Our ref: DOC20/941260

**Response to Submission comments for Intercontinental Hotel (former Treasury Building) of SSD project – Stage 2 (SSD 10454)**

**Steven Meredith**  
Regional Manager, South  
Heritage NSW  
Department of Premier and Cabinet  
**As Delegate of the Heritage Council of NSW**  
23 November 2020

Figure 14 | Existing and proposed balustrades (Source: Applicant’s Design Statement)

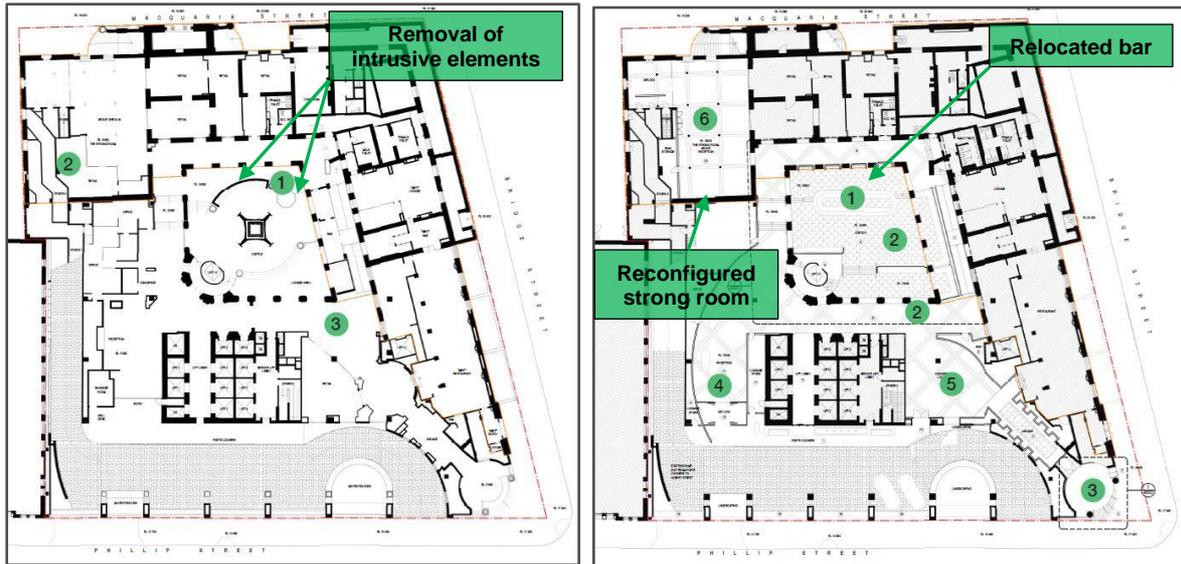
- The applicant and Heritage NSW continue to disagree on the details of the handrail located on Level 7. Review and reconsideration of the design of this handrail to minimise any visual impact is desirable.
- The applicant has noted all the other recommendations made by Heritage NSW and it is assumed that these recommendations would form part of the conditions of approval issued by DPIE.
